Application No: H09-0654-23 **Applicant:** Mr & Mrs J Slator

Proposal: Proposed first floor side extension and ground floor front extension (retrospective) - approved under H09-0499-20. Modification of Condition 1 to allow amendments to previously approved plans.

Location: 21 Langwith Drive Holbeach Spalding

Proposed Front (North) Elevation
Scale 1:100

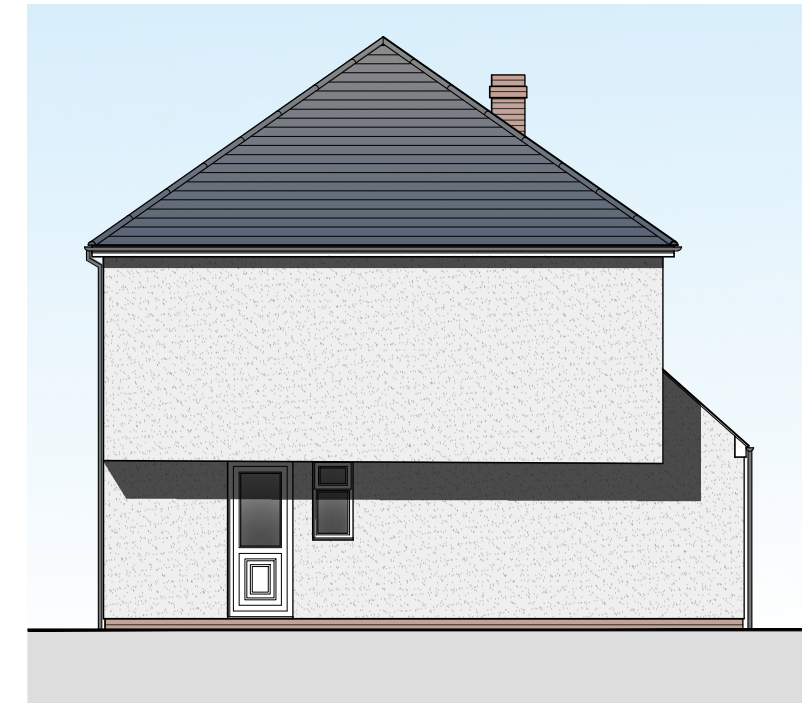
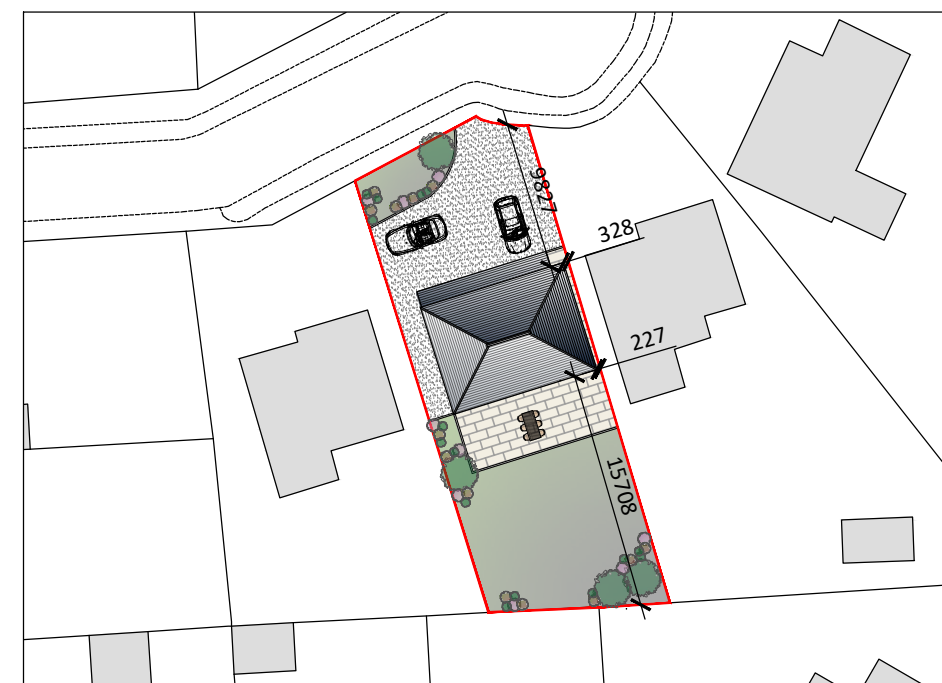
This application is a Section 73A seeking to vary Condition 1 of planning approval H09-0499-20. This variation seeks to alter the roof, including raising the ridge height of the dwelling by approximately 500mm and changing the design on the front elevation. The previous approval,

granted approval for an L shaped roof with a small gable edged window on the principle elevation. This variation proposes a hipped roof on all sides and this gable window design will be removed by raising the eaves to be level with those of the host dwelling.

As mentioned, the ridge height will be raised by approximately 500mm with the height of the eaves also being raised to be level with the existing. It is not considered that these changes will appear out of place and disproportionate to No. 21. Other properties within the immediate area incorporate hipped roofs and therefore by making this change, it is considered that the proposal would better suit the area and comprise an enhancement to the street scene in comparison to that previously approved.

There are no additional windows and therefore it is considered that there will be no overlooking concerns following approval on this application. The slight change to the window on the front elevation will not create any additional concerns as it will be facing the highway and provide neighbouring properties with adequate privacy.
